Consultation Response from KC, Conservation and Design
2021/93006 Yew Tree Farm, The Village, Farnley Tyas, Huddersfield, HD4 6UQ
Conversion of existing barn to form 8 dwellings, erection of 10 dwellings, demolition of redundant agricultural buildings and associated works (Listed Building within a Conservation Area)
Date Responded: 14.4.2023
Responding Officer: Sue Brooks
Responding Ref:

Following the previous response dated 7 October 2021 and the responses to the associated Listed Building Consent application 2021/93007 dated 7 October 2021 and 10 October 2022, amendments have been made to the proposal. The following comments are in response to these changes.

PROJECT TITLE YEW TREE FARM			
DRAWING TITLE HOUSE TYPE SEVEN			
SCALE 1:100	DRAWN JH	CHECKED JH	PROJECT REFERENCE ODS_20/294
PAPER SIZE A1	DWG NUMBER (72)007	DATE 16/04/21	REVISION A
CLIENT RADCLIFFE DEVELOPMENTS (FARNLEY)

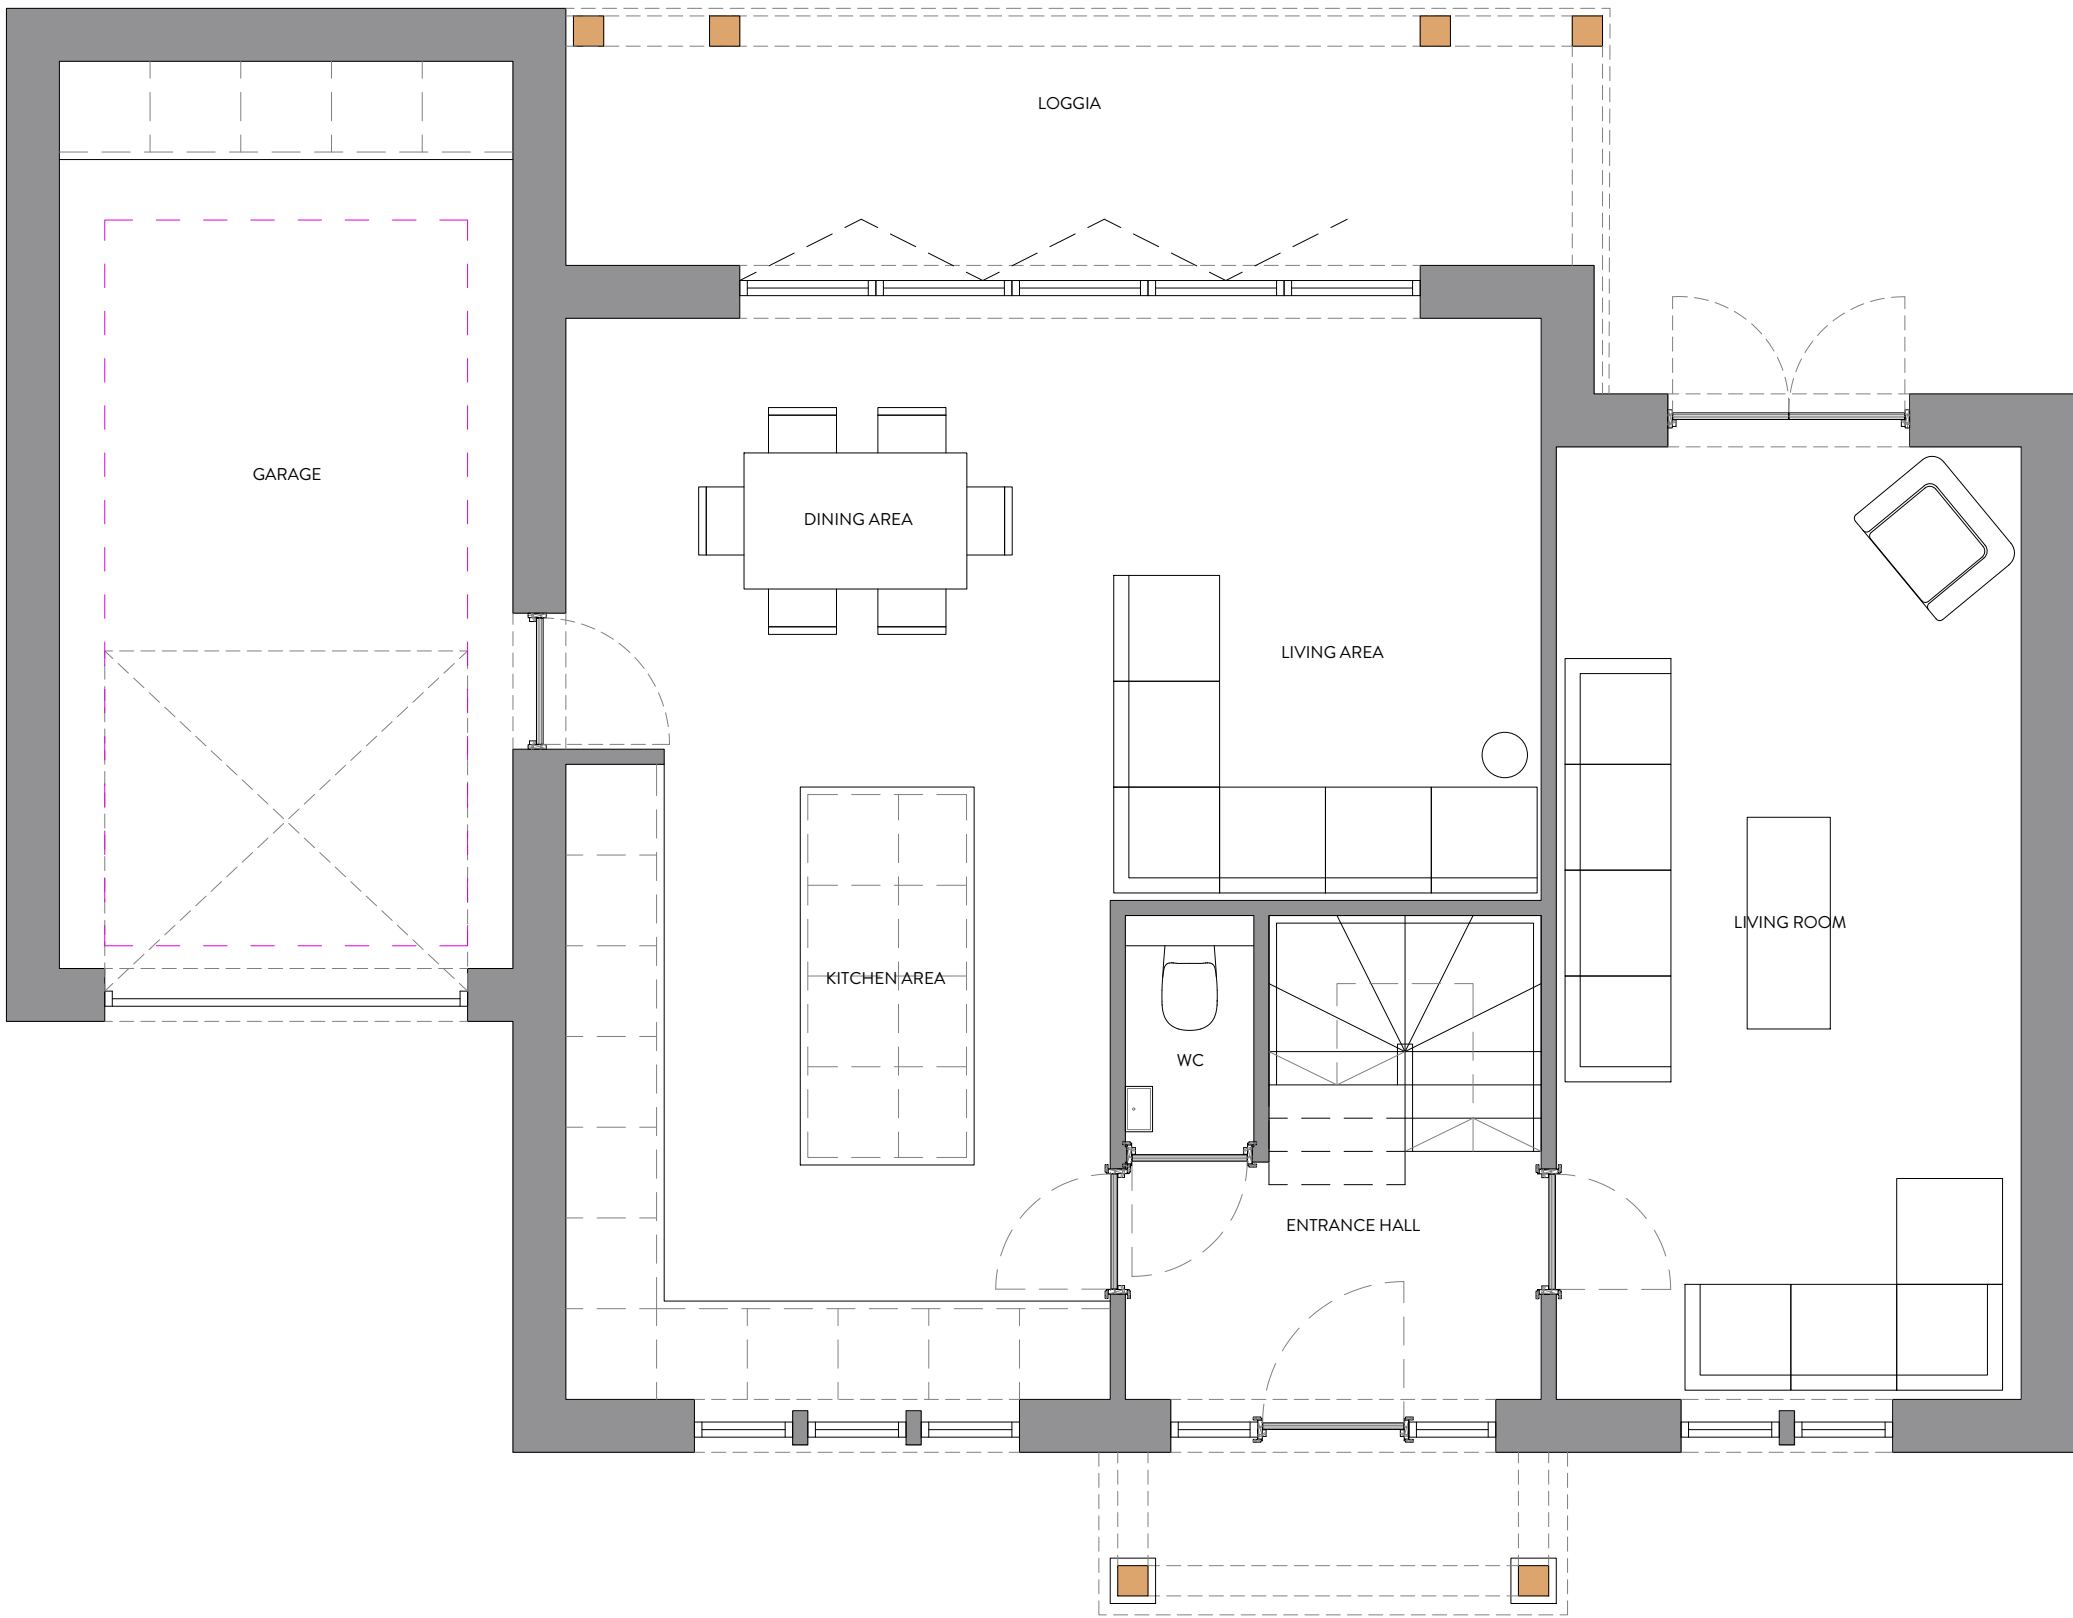
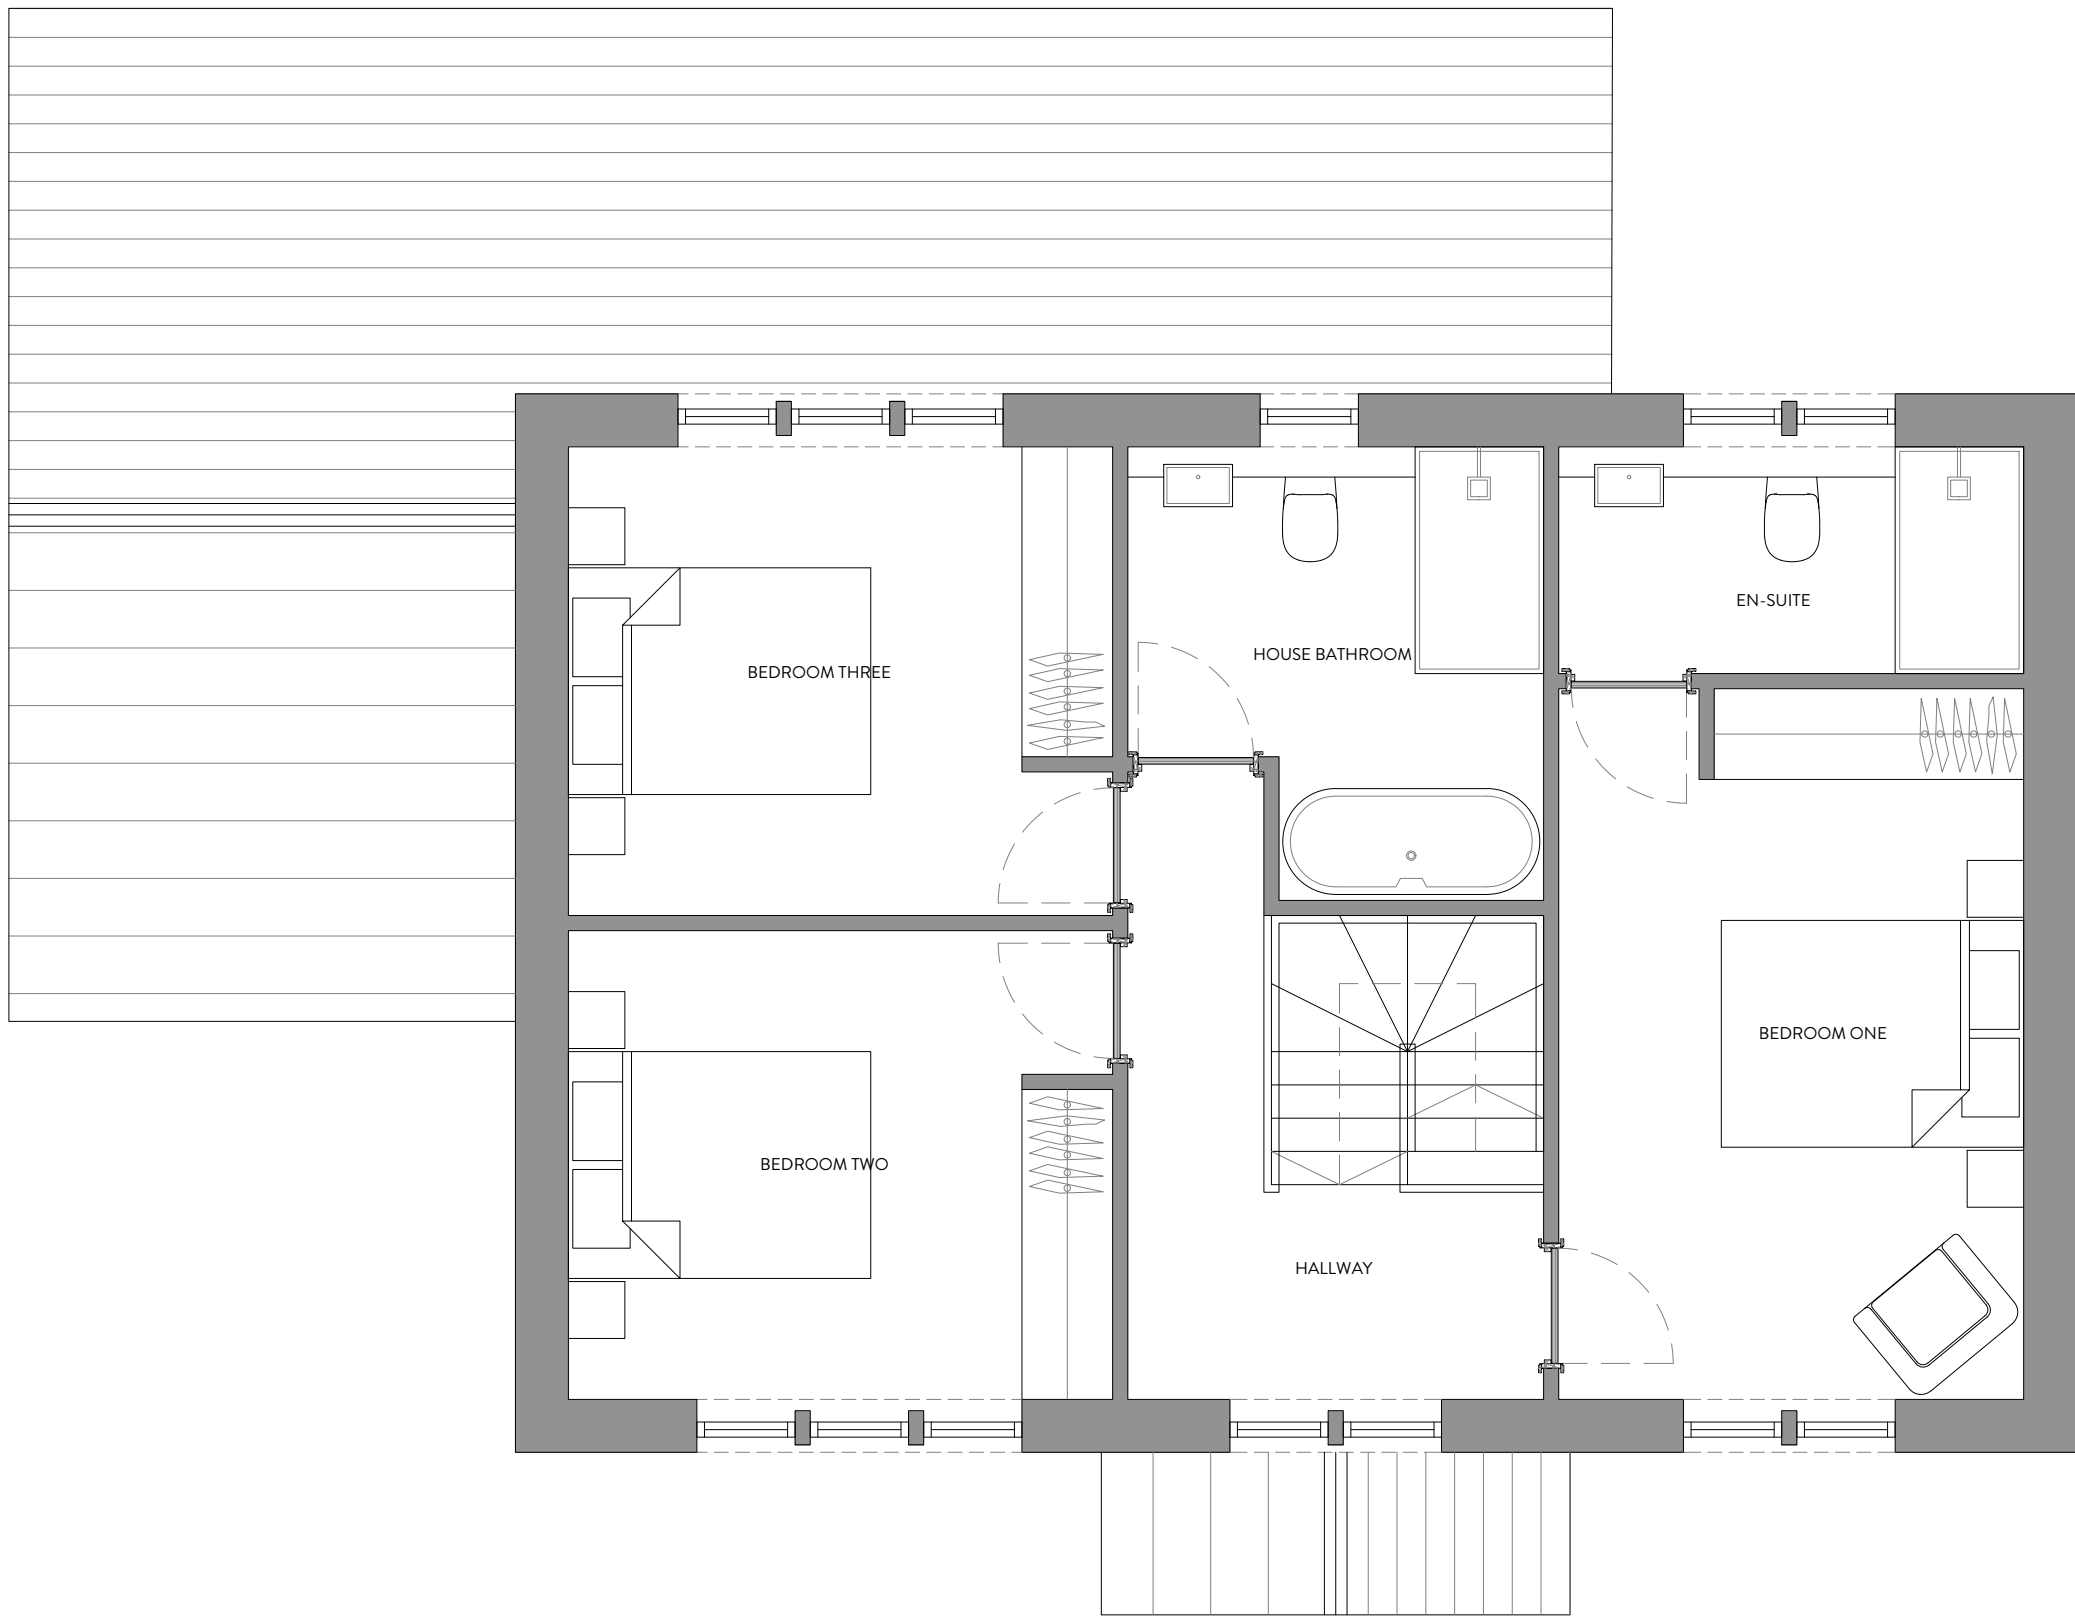
If the application is supported, we would recommend that external material samples are submitted for approval to ensure a high-quality finish. We would recommend that natural stone is specified for the roof slates and external walling, with pitch faced or tooled stone rather than tumbled and dyed stone.

- External material samples to be submitted for approval, including roof slates and ashlar stonework, with a sample panel of external walling including pointing and mortar colour. Pitch faced or tooled stone shall be specified rather than tumbled and dyed stone.
- Window and door details 1:5 and 1:20 to be submitted for approval.

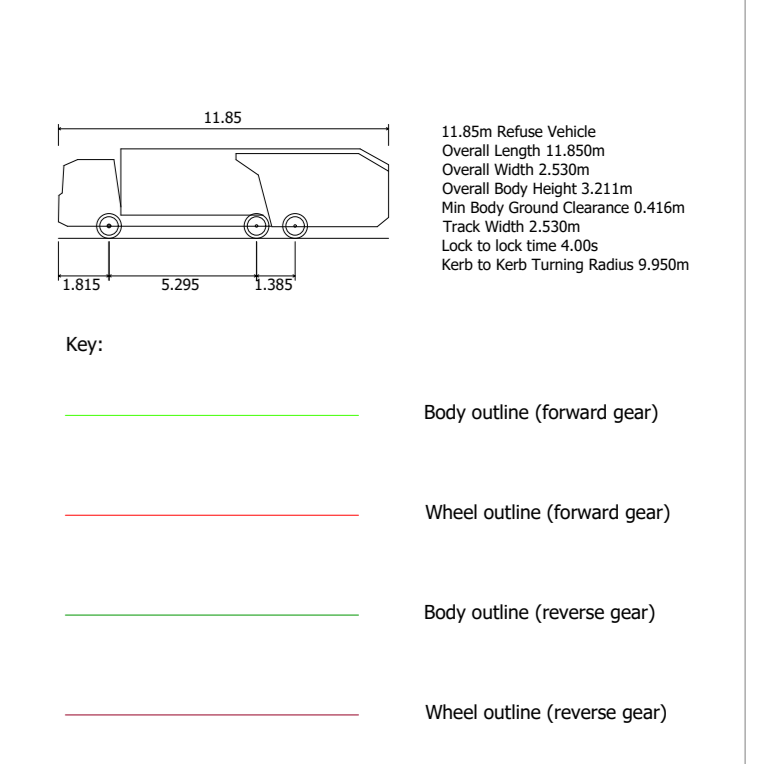
We welcome the use of 1m high metal estate railings within the farmyard at the north-east corner of the site, and dry-stone walling on the southern boundary facing the open fields. We still have concerns about solid vertical boarded 1.8m high timber fencing in the rear gardens which is shown on the proposed site plan (20)001 rev G.

A car park is proposed on the northern boundary of the site, adjacent to the proposed site access and in an open space between the two large, listed barns. The creation of parking in this prominent location will harm the setting of the farm group and we suggested that alternatives were considered where the impact is lower, perhaps to the rear of the listed farm group. The layout will not be amended due to site constraints.

We would recommend that 1.8m high fencing is omitted and replaced with lower boundary treatments or soft landscaping.

The location of car parking is accepted subject to suitable landscaping being proposed in this area.

- Omission of 1.8m high fencing and replacement with lower boundary treatments or soft landscaping. Details to be submitted.
- Landscaping details including surface treatments.
